From: Amanda Scholes on behalf of Planning.Responses
Sent: 12 November 2020 09:20
To: Planning Scanning
Subject: FW: A/157/20/DOC - Land South of Water Lane, Angmering.
Attachments: A290-R002G Construction Management Plan.pdf

From: Carol Reynolds <Carol.Reynolds@arun.gov.uk>
Sent: 11 November 2020 15:45
To: Michael Eastham <Michael.Eastham@arun.gov.uk>
Subject: A/157/20/DOC - Land South of Water Lane, Angmering.

Environmental Health: I refer to that CMP provided by Abbey Letchford Partnership dated 28th October 2020 Ref A290-R002/G.

Appendix C – Routing Plan

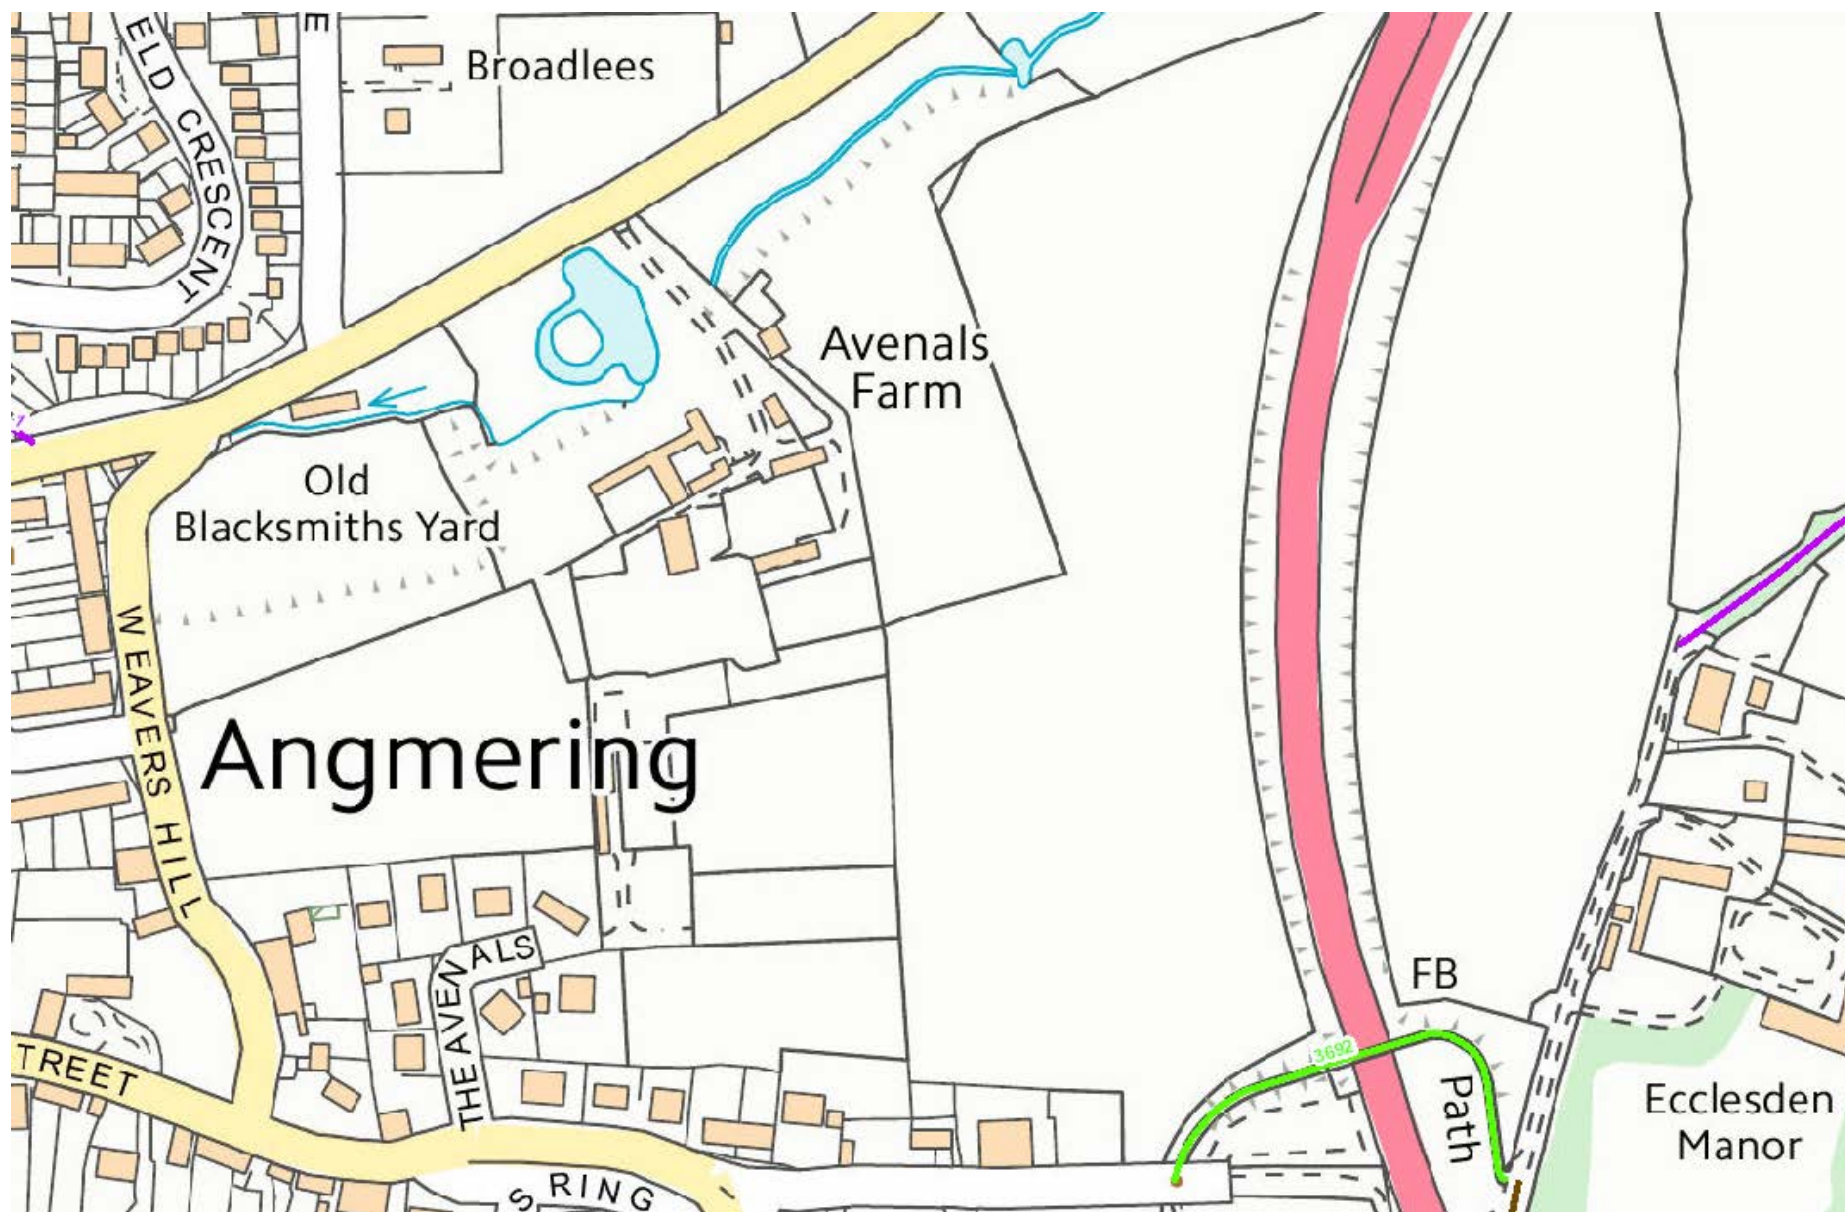
I note that the above document seeks to expedite construction of the northern access way to Water Lane, so that this will now occur at the same time as site infrastructure works. Also, that greater explanation has been provided of proposed routing of vehicles, including HGVs, via Weavers Hill and the High Street. I had, however, already advised (please see my return 22nd October 2020), that sufficient consideration had not been provided to the likely detrimental impact of noise and vibration from such site traffic on residential units to the High Street. I had also highlighted the many residential units on Weavers Hill, including those where the gable wall directly borders this road.

It is further noted that the time frame over which use of this proposed route will continue, described as until the northern access is constructed to base course level to allow construction vehicle access (paragraph 2.6) is unclear, but would appear to be at least until 2022 (paragraph 2.3). Choice of this route is therefore likely to mean that sensitive receptors will experience noise and/or vibration detriment over a significant period of time.

The situation is exacerbated by the fact that there will be an anticipated 20 to 30 HGV movements per day (equivalent to 2-3 movements per hour) along these narrow roads during construction of the haul road (Paragraph 2.24). There will also be a significant number of HGV movements here during construction of the High Street access from the south of the site, consisting 1 to 2 HGV movements per hour. The timeframe of such works requires greater definition, as does the number of light vehicle movements which would occur at this time.

The number of HGV movements during the house construction phase is stated to reduce to a maximum of 8 HGV lorries together with 95, two way movements of private (builders) vehicles per day, but is still significant.

I note Ian Geldhill's statement that Weavers Hill is 'wholly unsuitable for HGV access' and that other roads within Angmering Village (may also be unsuitable, as they...) are subject to legally enforceable width restrictions.

Overall, I consider it unreasonable to divert construction traffic as described, over a prolonged period, through Angmering village, including Weavers Hill and the High Street. The Construction Management Plan should allow for the provision of a temporary (or permanent) bridge allowing access to the site from Water Lane from the outset.
